Development Control
Ribbles Valley Borough Council

App no: 23.0754

Address: Judge Walmsley Mill Longworth Road Billington

Proposal: Proposed change of use of agricultural land to new car park and storage yard

dwg purpose  
Proposed Car Park

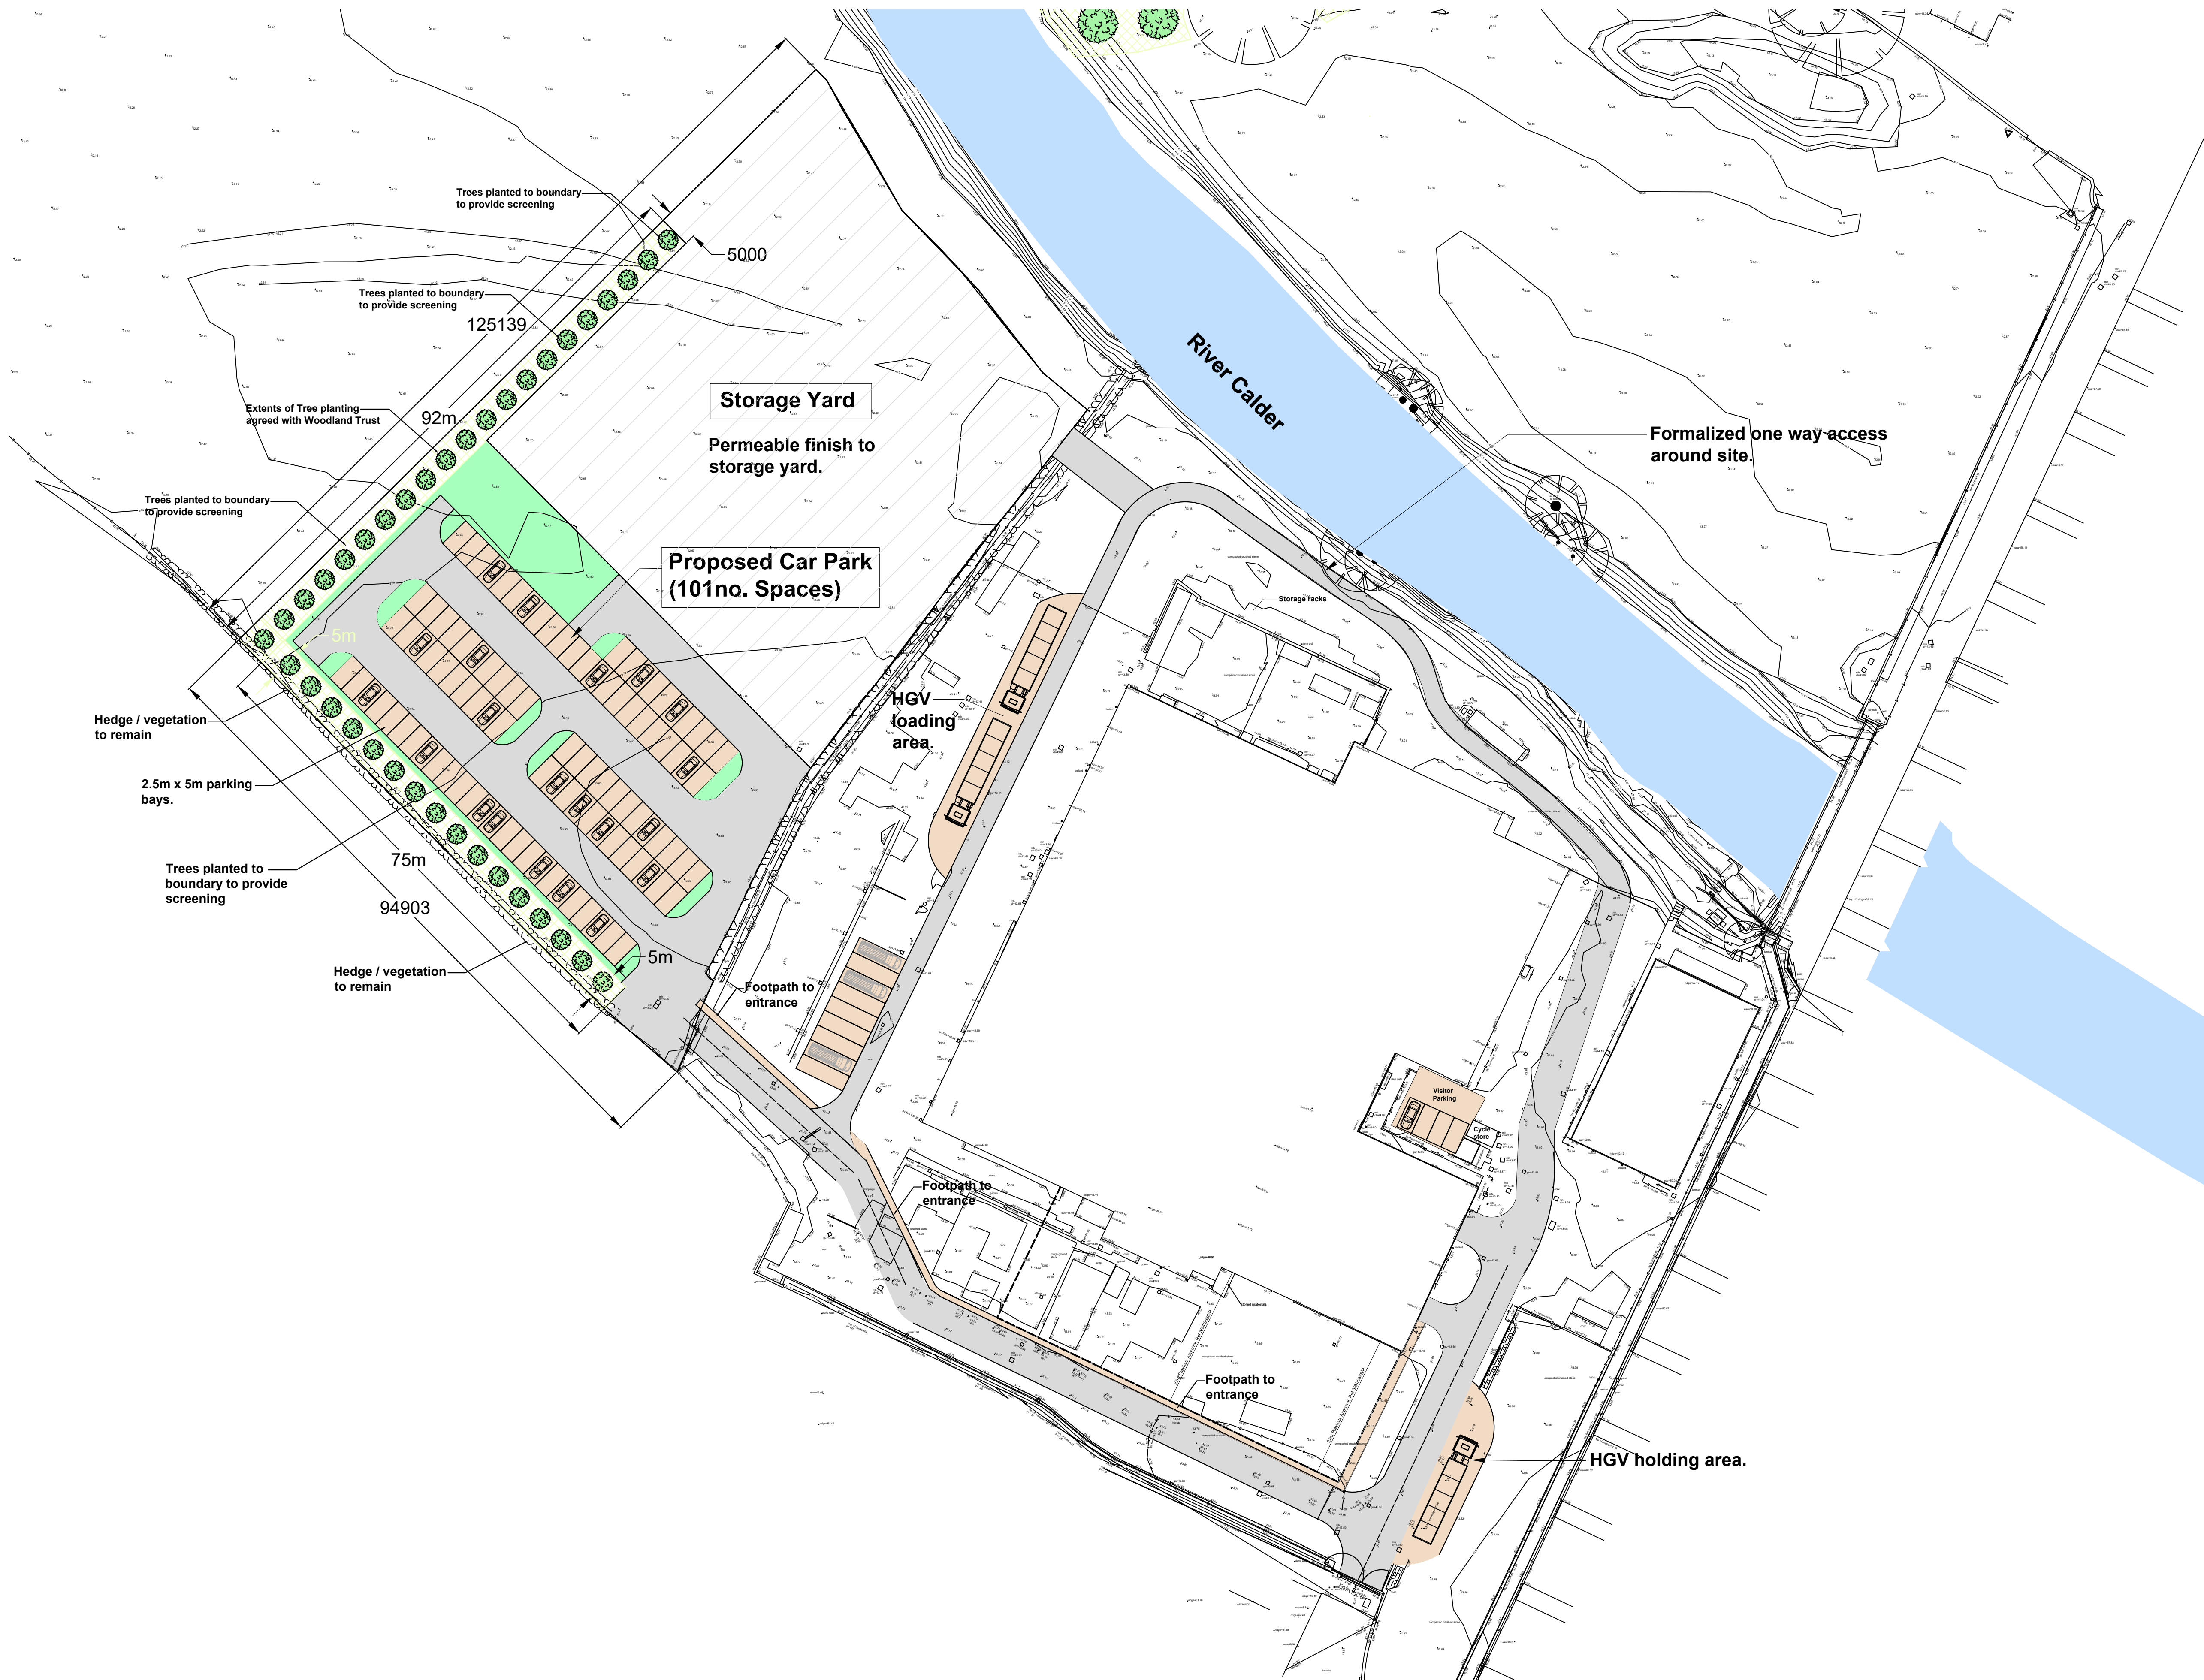
There are 101 spaces plus 4 visitor spaces and 9 van spaces proposed, totalling 114 spaces. This is a small increase on the existing 99 spaces.

Secure, covered cycle parking and electric vehicle charging points should be provided to support sustainable travel at a rate of 10% of the parking provision which equates to 11 cycle spaces and 11 electric charging points.

2. Prior to first use of the development hereby permitted a secure cycle store for at least 11 bicycles shall be provided and 11 electric vehicle charging points.
Reason: To support sustainable travel
